From: Glenn Gasson <[REDACTED]>
Sent: 17 January 2022 15:47
To: Simon Davis
Cc: Shane Noone; Neil Drinkwater
Subject: RE: Planning Consultation on: A/255/21/DOC
Attachments: GD-Group-Drainage-Report-Update.pdf

From: Simon Davis <Simon.Davis@arun.gov.uk>
Sent: 11 January 2022 13:40
To: Glenn Gasson <[REDACTED]>
Cc: Shane Noone <[REDACTED]> Neil Drinkwater <[REDACTED]>
Subject: RE: Planning Consultation on: A/255/21/DOC

The invoice for the attenuation tanks states that 196 Polystorm PSM1 crates were ordered. We believe that the design requires over 700 crates. -- We are locating the additional invoice for the remaining 320No. attenuation crates, I will send this over to you for review, (for the record there are 516 No. crates required to achieve the attenuation capacities to AT1 & AT2.)

<p>cgs civils Consulting Civil Engineers</p>					
CLIENT		GD GROUP			
ARCHITECT		CITYZEN			
JOB TITLE		MERRY ENGLAND ANGMERING			
DRAWING TITLE		DRAINAGE LAYOUT			
DRAWN	LH	ENGINEER	CS	CHECKED	CS
DATE	SEPT 2019		1:200		
DRAWING No.	C1249	STATUS	C	DRAWING No.	100
REV	A

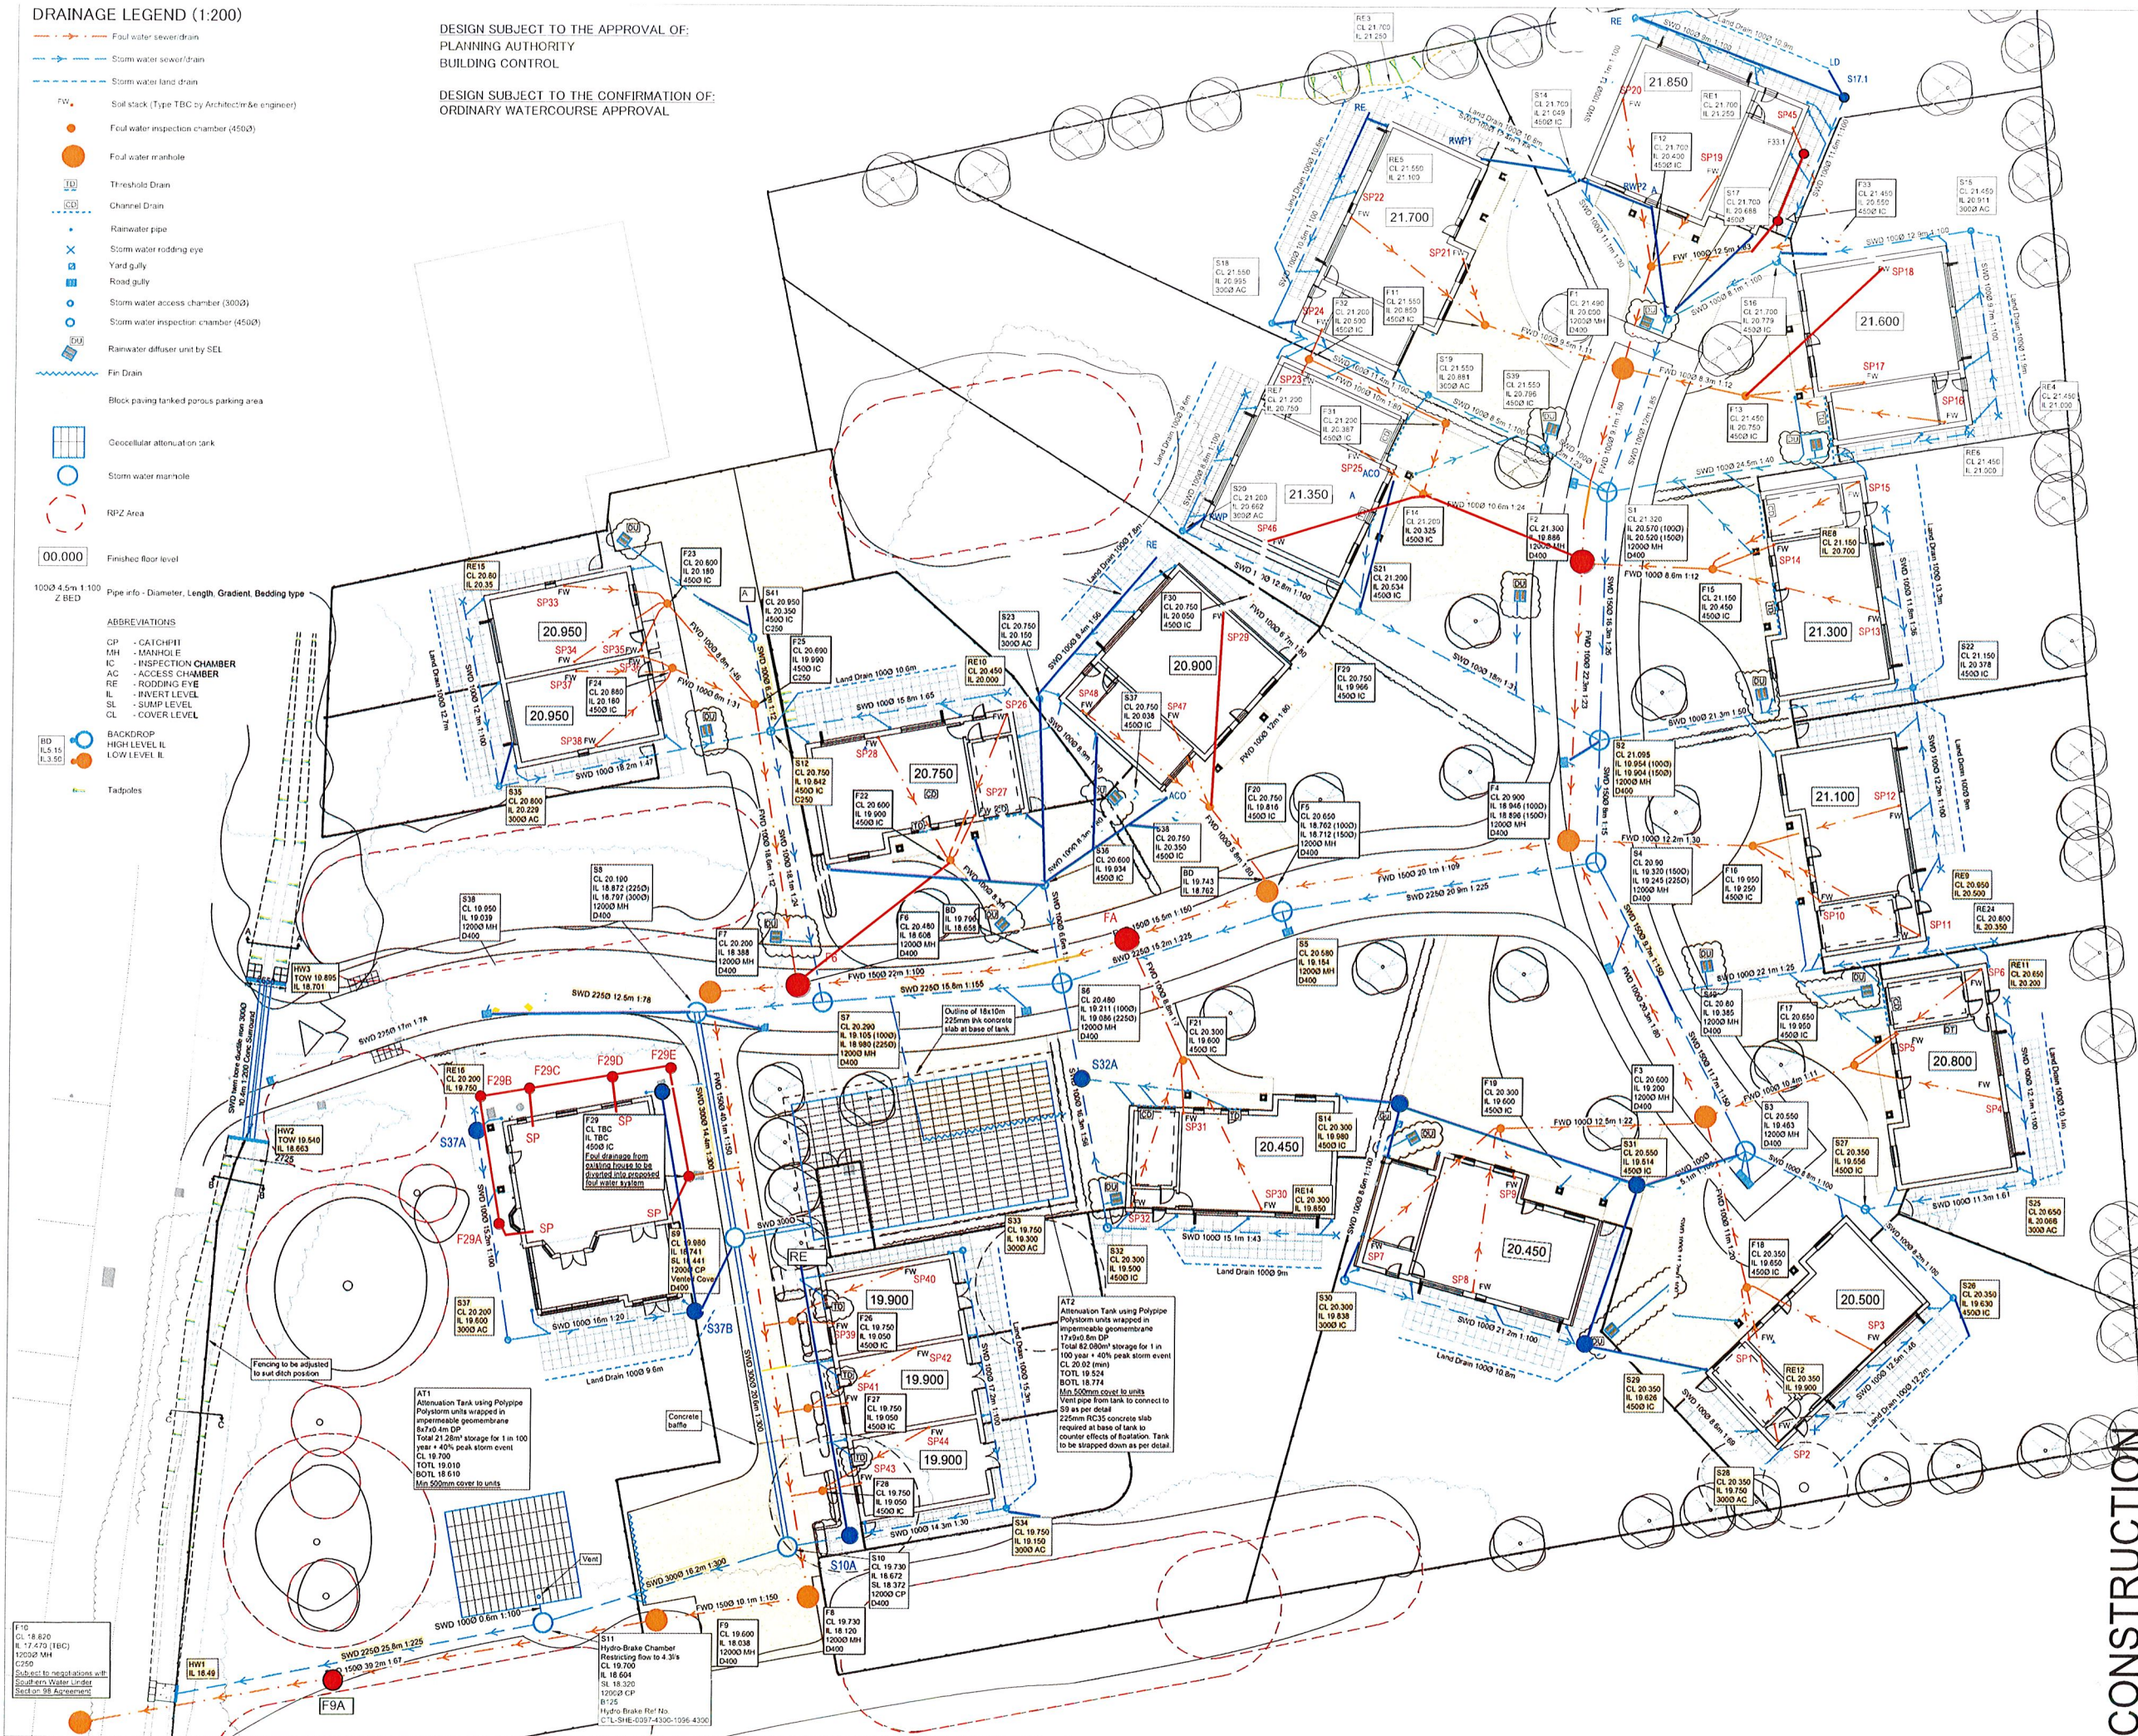
The photos supplied to evidence the construction of AT2 clearly show that this attenuation tank has been constructed to only one crate depth, despite the design specifying two crates depth. The photo also appears to show Terram surround the crates, but no impermeable tanking membrane.- there are two layers of 1m x 0.5m x 0.4m Polystorm PSM1 crates, with 500mm cover, you can see from the adjacent ground levels on Fig 9 that this is the first 1m x 0.5m x 0.4mm layer of crates, Fig 8 shows the second layer of crates, when I send the additional crate invoice over this should show the correct amount of crates.

Please also clearly detail if each of the defects picked up by the independent engineer have been rectified. Five photos have been supplied, but more than 5 defects were identified. -- Please refer to the attached Drainage Report Update dated 13th January 2022, this shows the defects picked up in the Independent Engineers Report being remediated.

We do not recommend discharge of condition 5 at this time as the evidence supplied raises significant questions about the construction. Please supply evidence that construction has occurred in accordance with the design. It may be that some areas need to be reconstructed.
